PCD FILE NO. PPR-21-024

DRAWN BY: O.E. WATTS	APPROVED BY:	REVISIONS 3-16-21 REVISED BUILDINGS DEW	PROJECT 10659 MALTESE POINT LOT 11, ROLLING THUNDER BUSINESS PARK EL PASO COUNTY	SHT. NAME GRADING AND EROSION CONTROL PLAN	SHT. NO. 2 OF 4
DATE: 4-2-21	PROJ. NO.	9-27-21 REVISED PER COUNTY REVIEW COMMENTS DEW			
DWG. NO.: 20-5509-07	DWG.	12-30-21 REVISED PER COUNTY REVIEW COMMENTS DEW			
SURVEYED BY: DEW, CSW, 6-26-19, 9-24-20		8-11-22 REVISED PER COUNTY REVIEW COMMENTS DEW

POND INLET DETAIL
1/2"=1'-0"

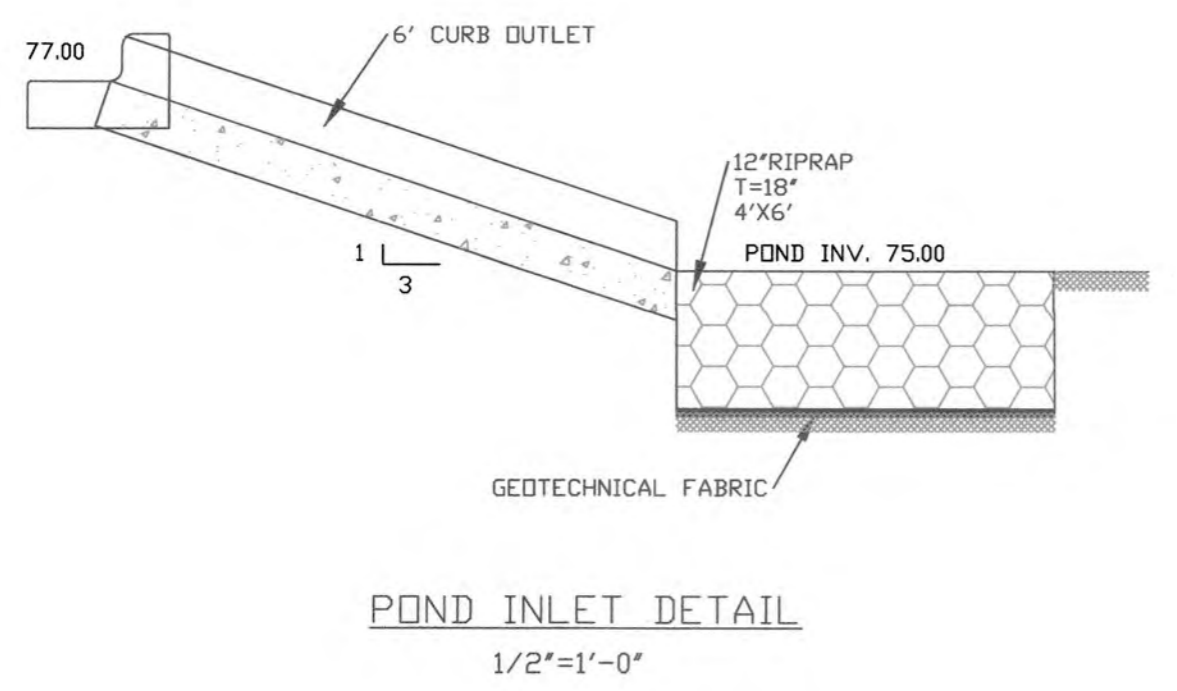
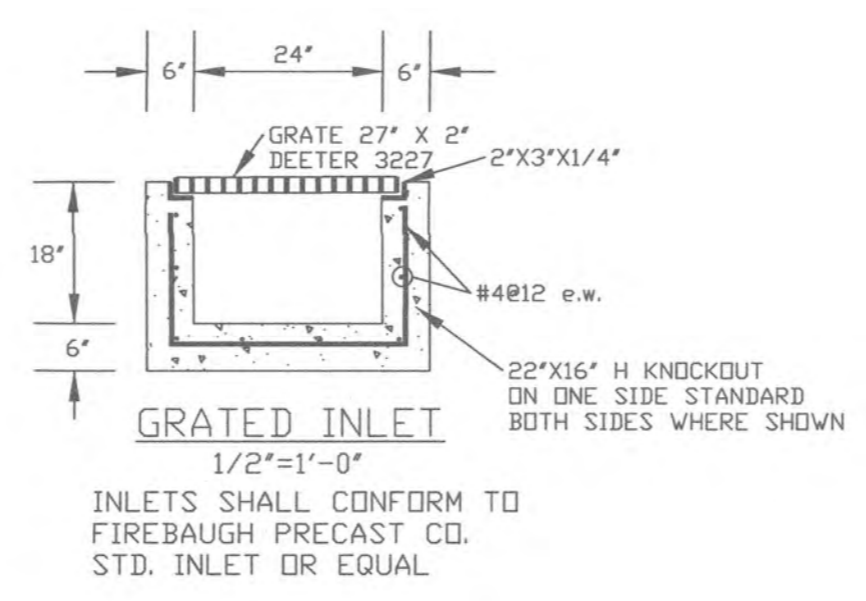
This is for a PLD. Revise since you are proposing a SFB.

SAND FILTER POND DETAIL
NOT TO SCALE

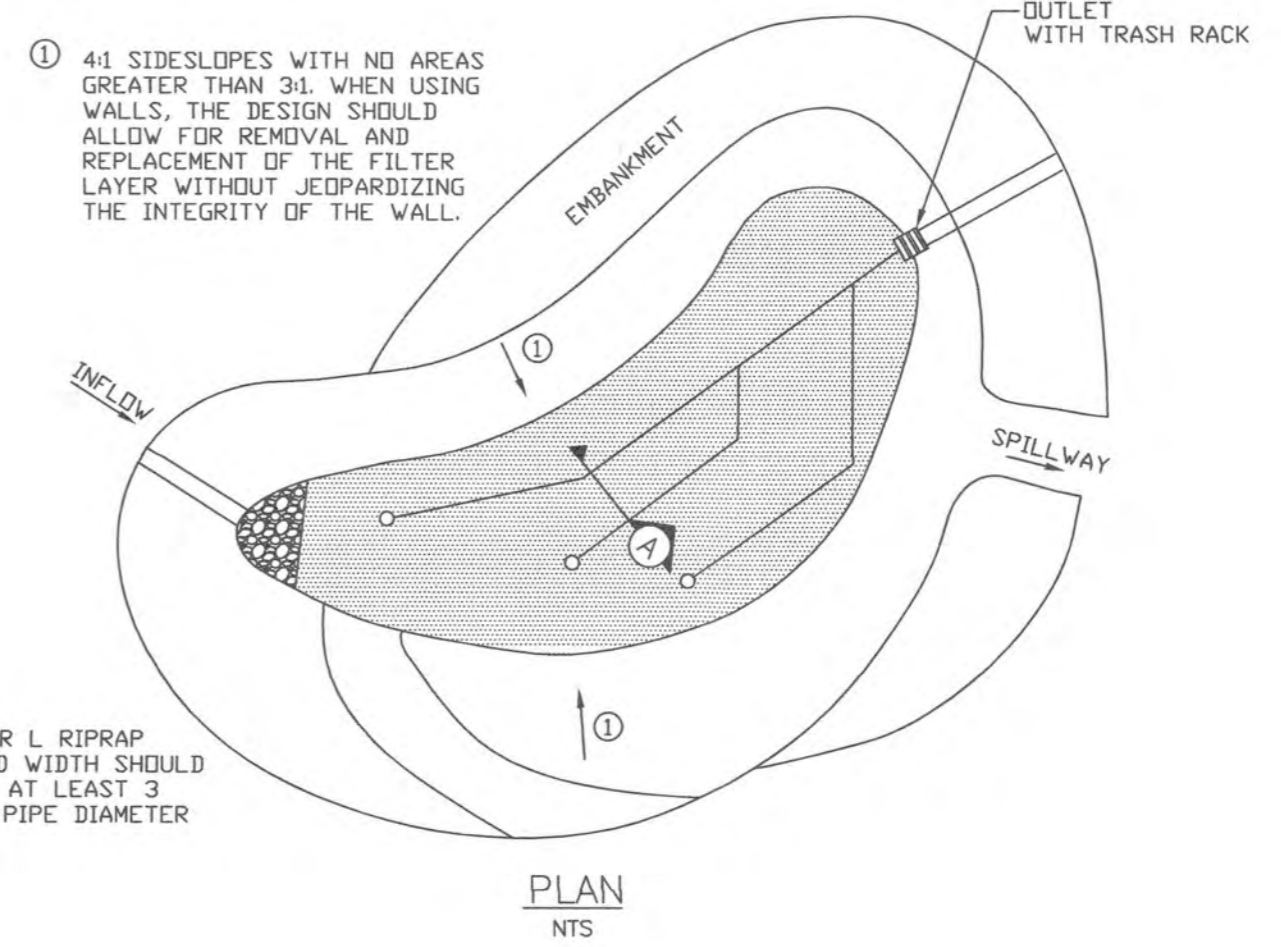
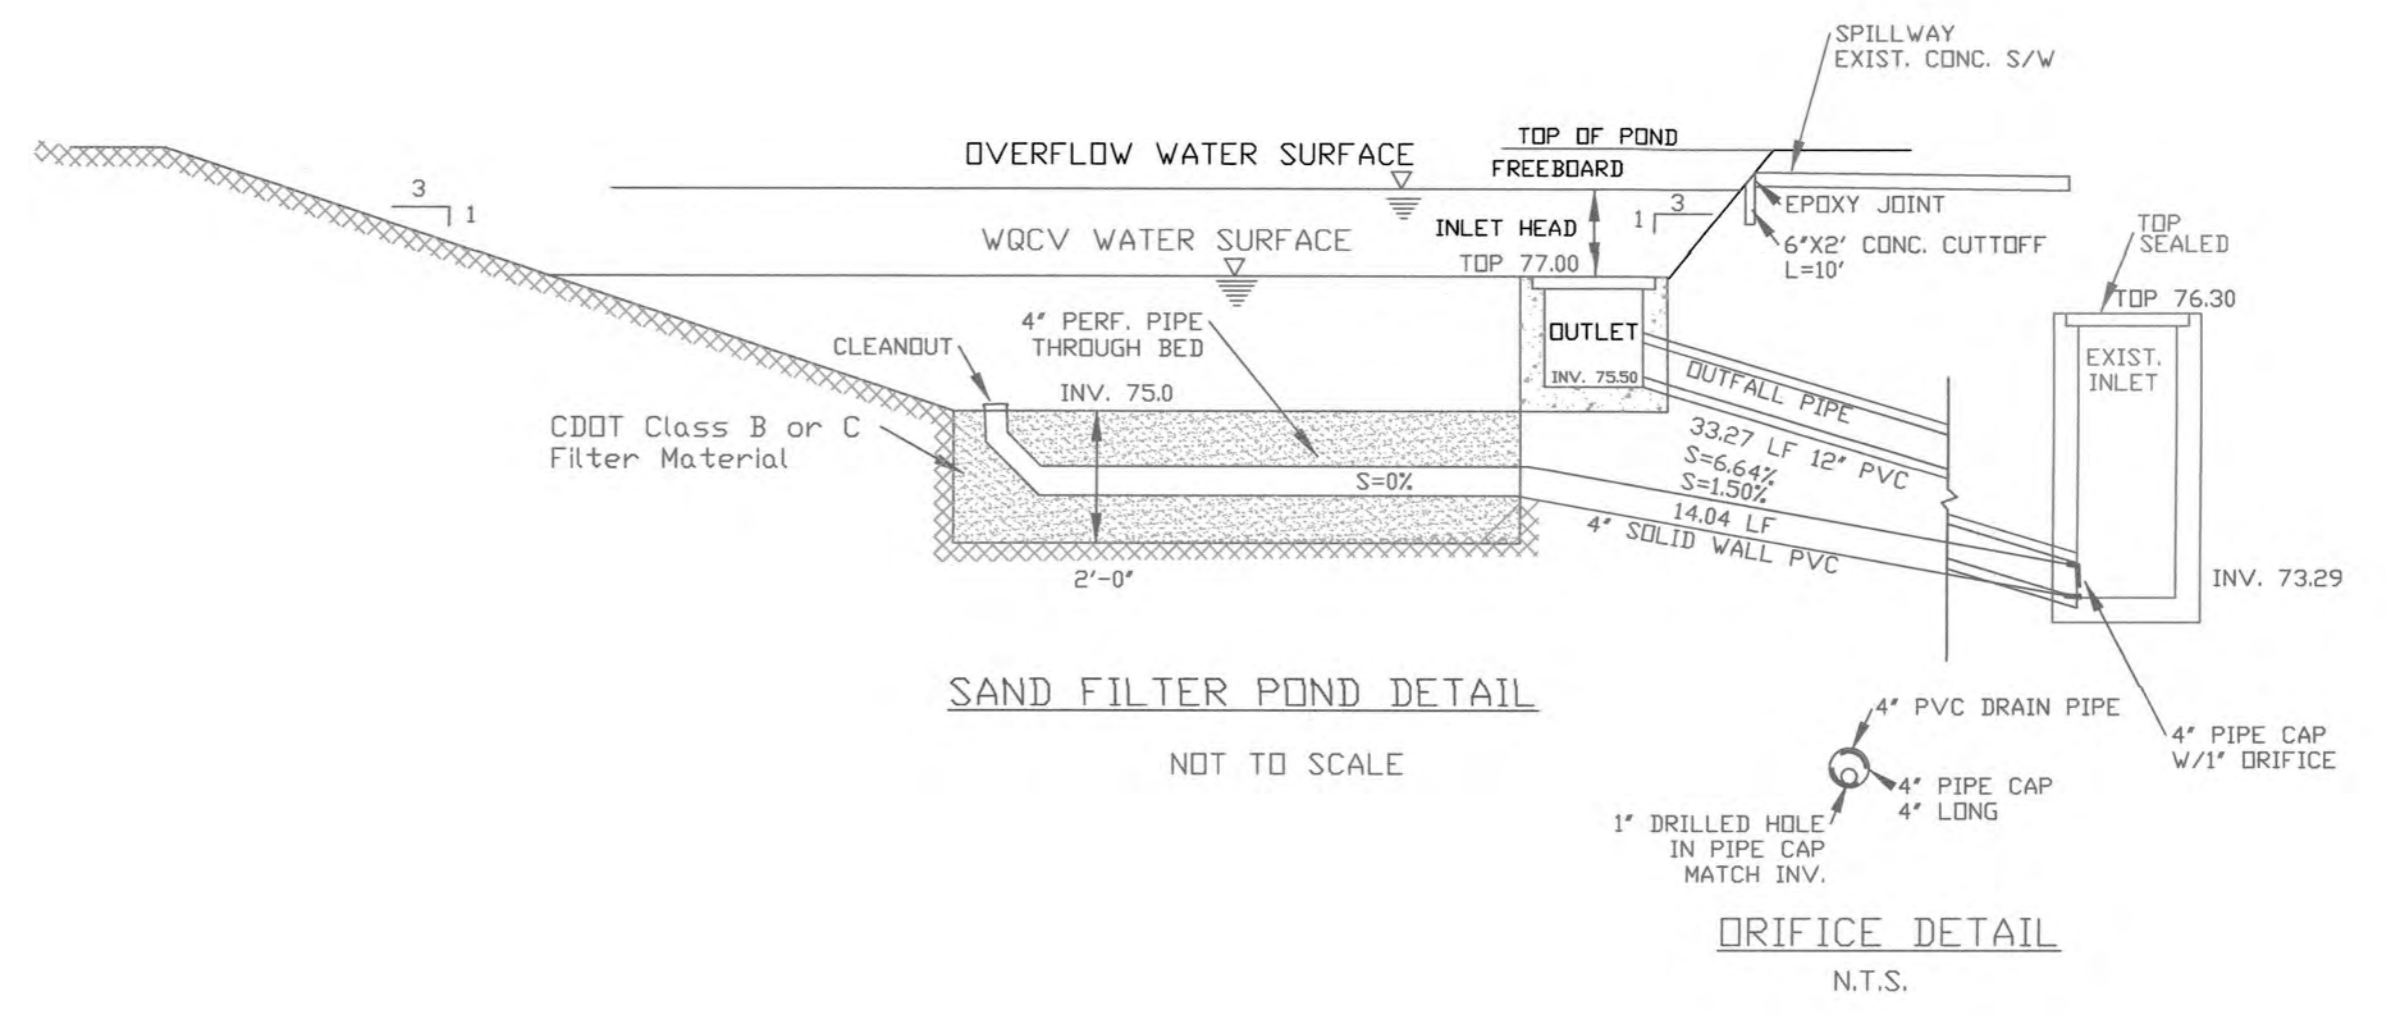
Provide orifice plate detail. Unresolved.

This is for a PLD. Revise since you are proposing a SFB.

The 18" outfall pipe is too large to tie into the 18" outlet structure. Unresolved.
